DECISION DELEGATED TO DEVELOPMENT MANAGER

Application No: H02-0660-21 **Applicant:** Mr G Robson

Proposal: Proposed extension & alterations and new garage - approved under H02-0272-21. Amendments to increase in size of garage and change to garage materials

Location: 63 Jubilee Way Crowland Peterborough

Drawing No.
02F

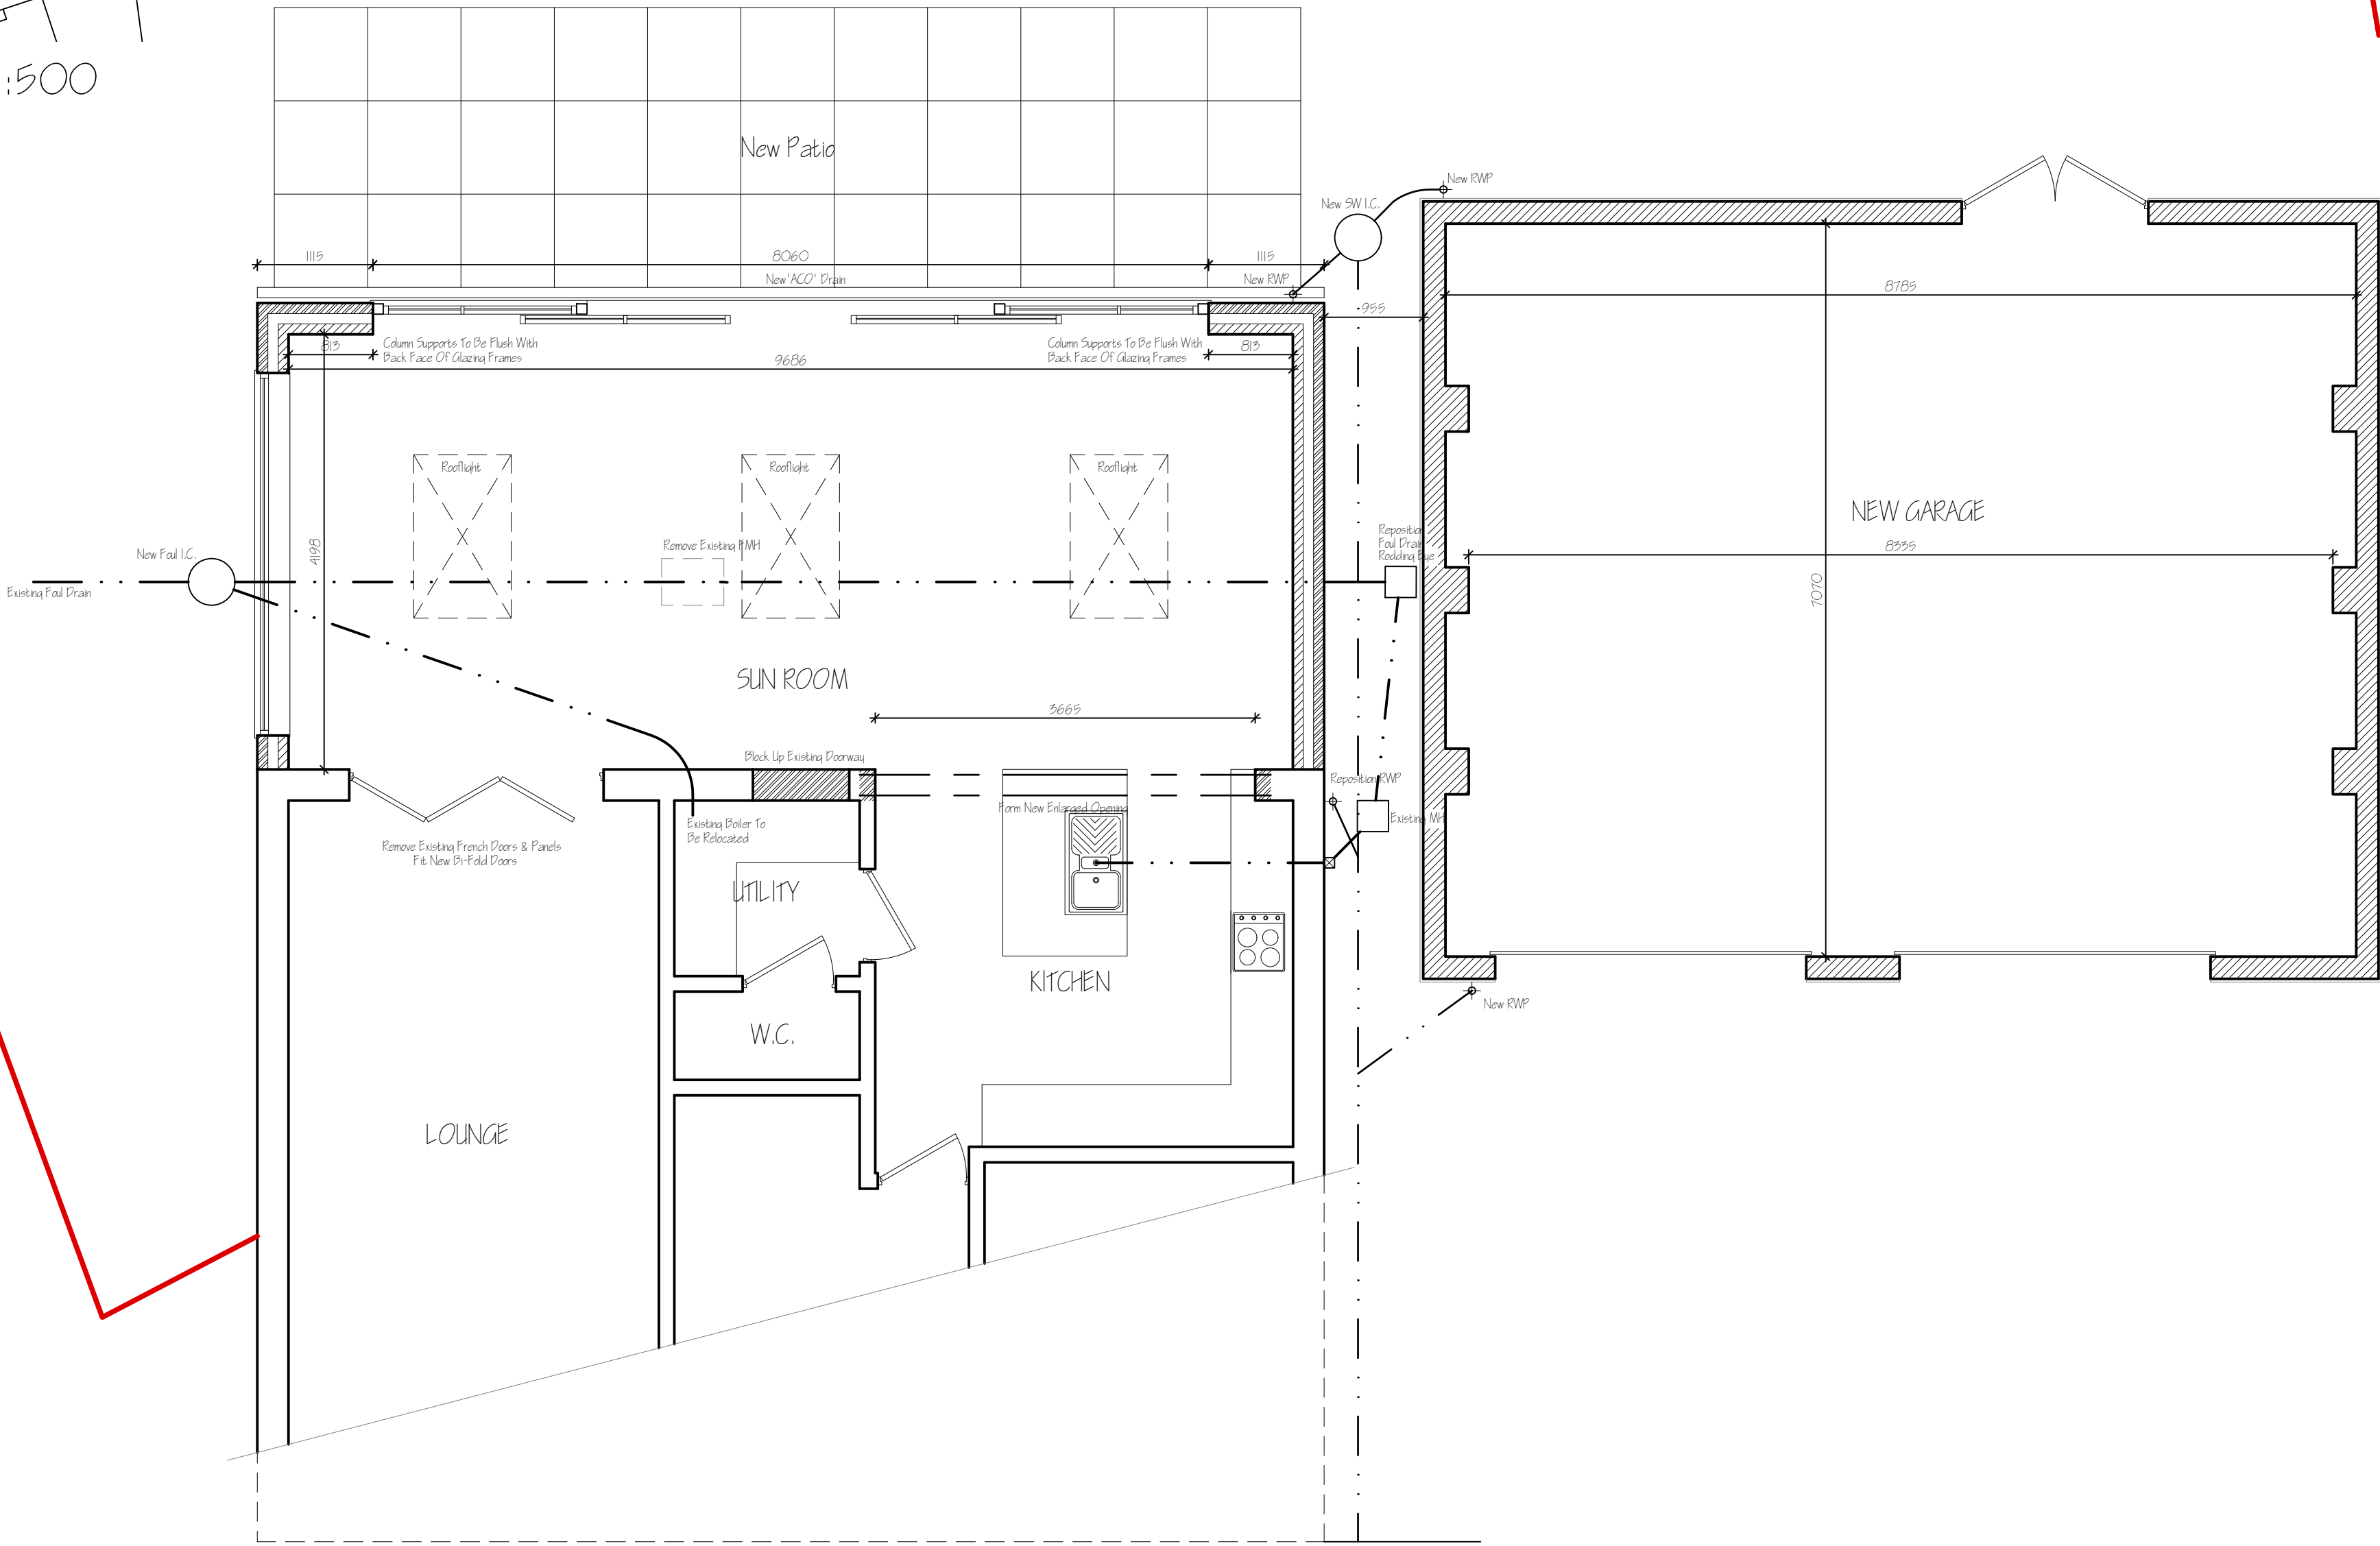
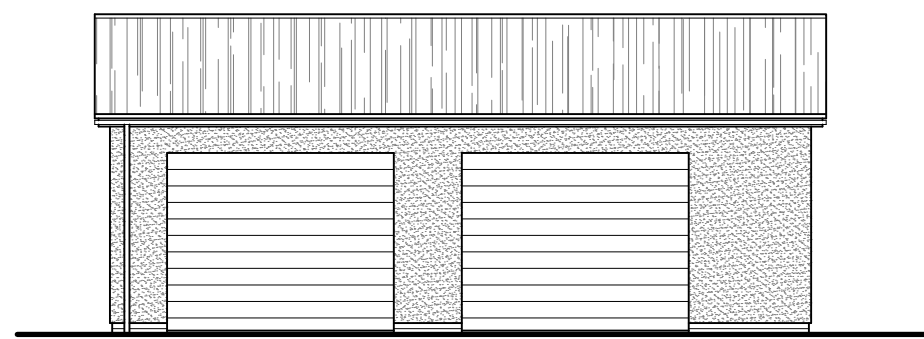
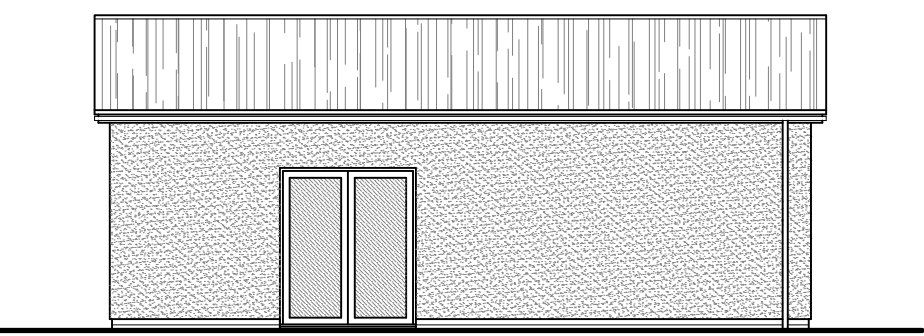
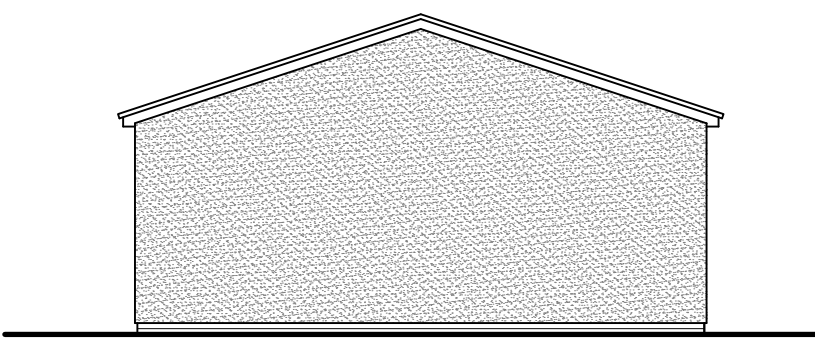
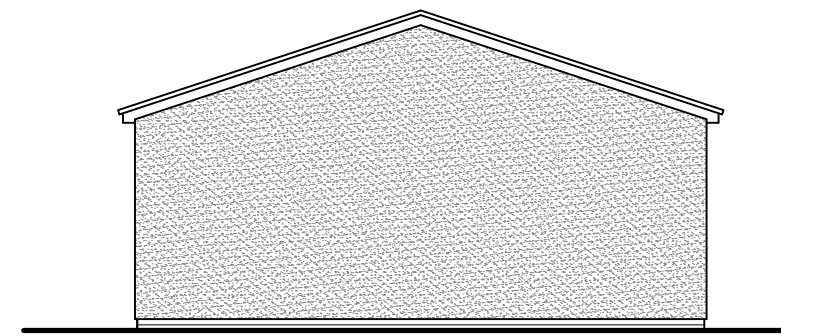
This application proposes to increase the size of the detached garage permitted under planning permission H02-272-21 by 45mm in width and 340mm in depth. It is also proposed to change the materials from bricks and tiles to match the main house to block walls with K render in dark grey, with dark grey raised profile PIR panels for the roof.

4. There is a prescriptive condition on the original permission that matching external materials be used. This would remain the case for the rear extension but different materials are now proposed for the garage;

8. The proposal relates to the detached garage rather than the rear extension. The increase in footprint is marginal and may be considered to be non-material. There is no change in height. It is not uncommon for detached garages to be constructed in different materials and in this case the proposed siting to the side of the house means that it would not be visible from the highway;

Overall, it is considered that the proposed amendments satisfactorily comply with the criteria of South Holland District Council's Development Control Procedure Note Non-Material Amendments to Planning Permission and, as such, are acceptable as a Non-Material Amendment.
